**State Significant Development 7235
Proposed Warehouse and Distribution Facility, 2 & 12 Hume Highway Chullora (Lot 12 in
DP834734 & Lot 1020 in DP871836) - Response to Submissions**

Table 1: Proponent Response to Agencies

INTERSECTION DETAILS

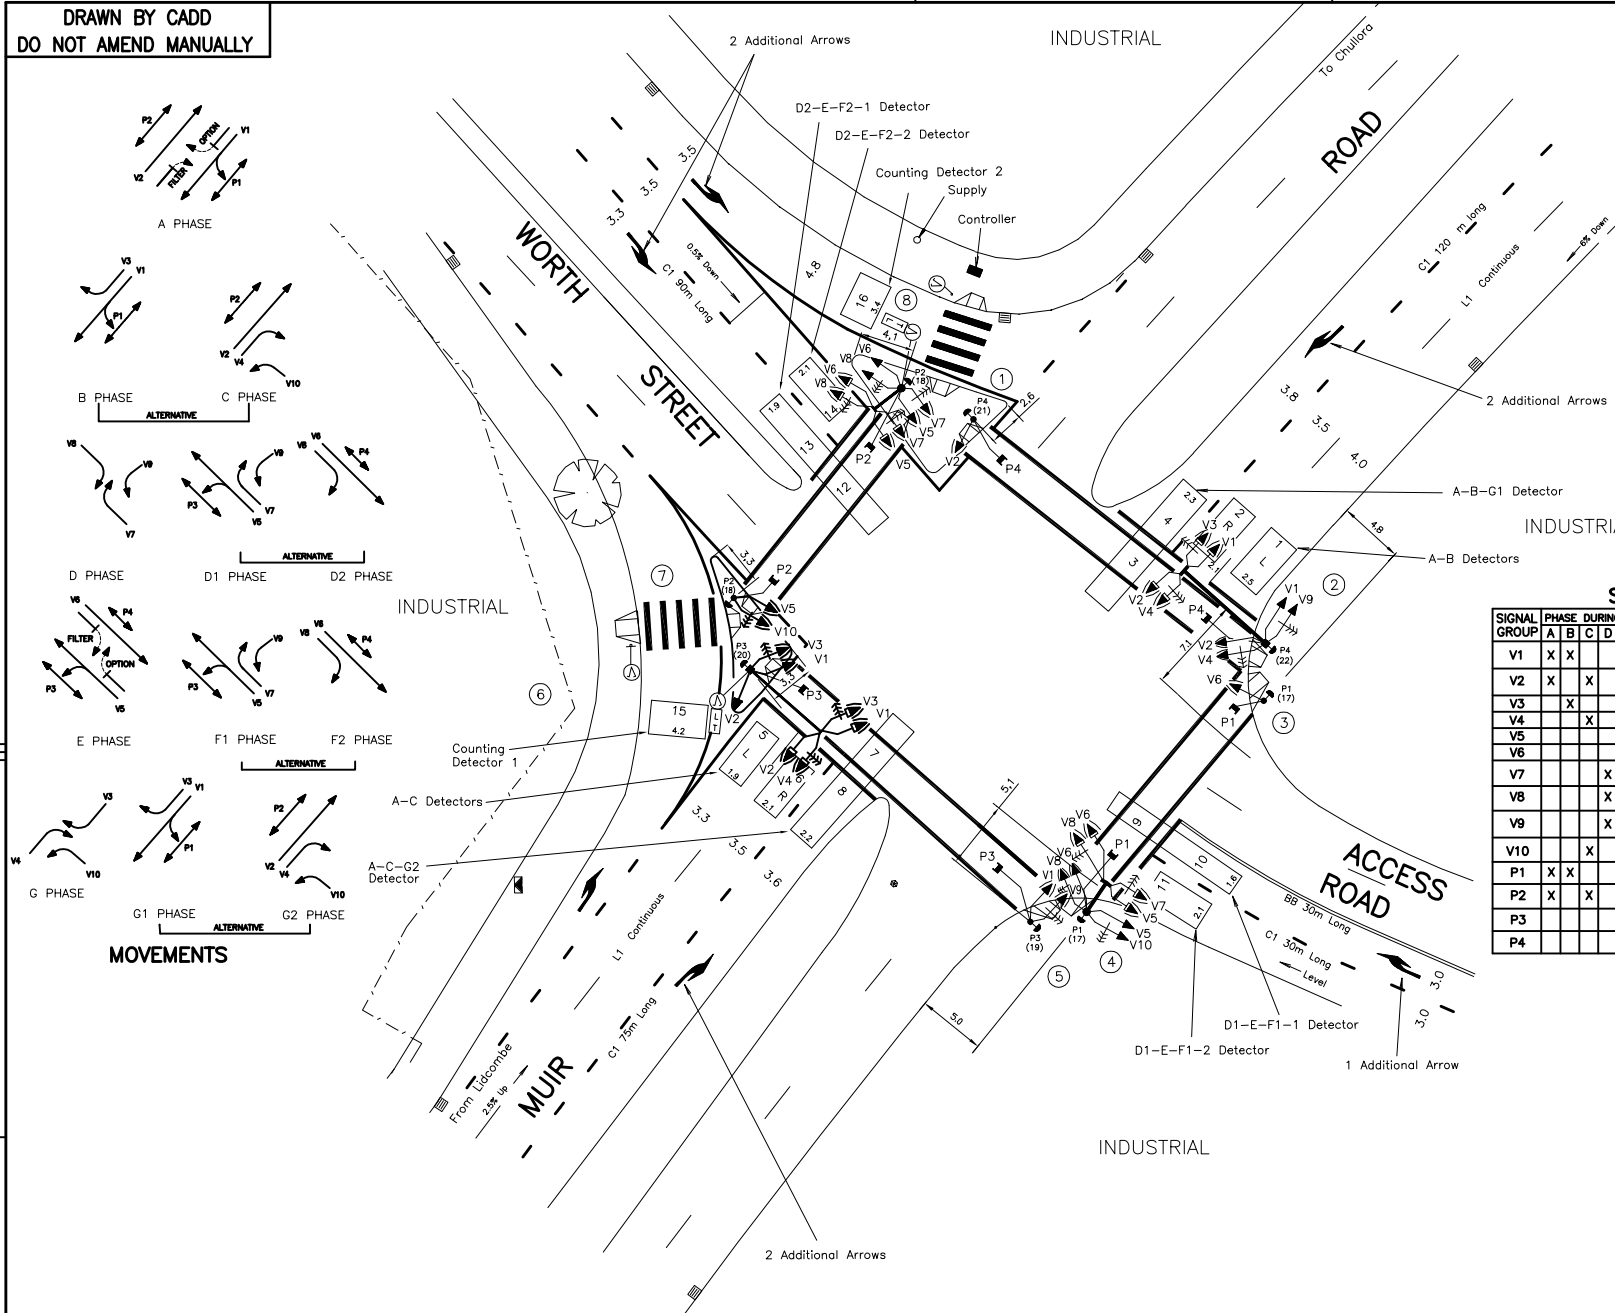
6. Vehicle access safety <i>There is concern the location of the proposed driveways on Worth Street will be unsafe for vehicles entering and exiting the site due to limited sight lines of oncoming traffic.</i> <i>The proposed development must provide traffic mitigation works to reduce this safety risk. Any mitigation works proposed on Council managed roads and land must be negotiated prior to the determination of the proposed development.</i>	In light of the comments provided by Council, our traffic consultant TTPA has reviewed the proposal and confirmed that the site distances are satisfactory subject to installing 'No Stopping' signs generally as shown in Appendix 3.
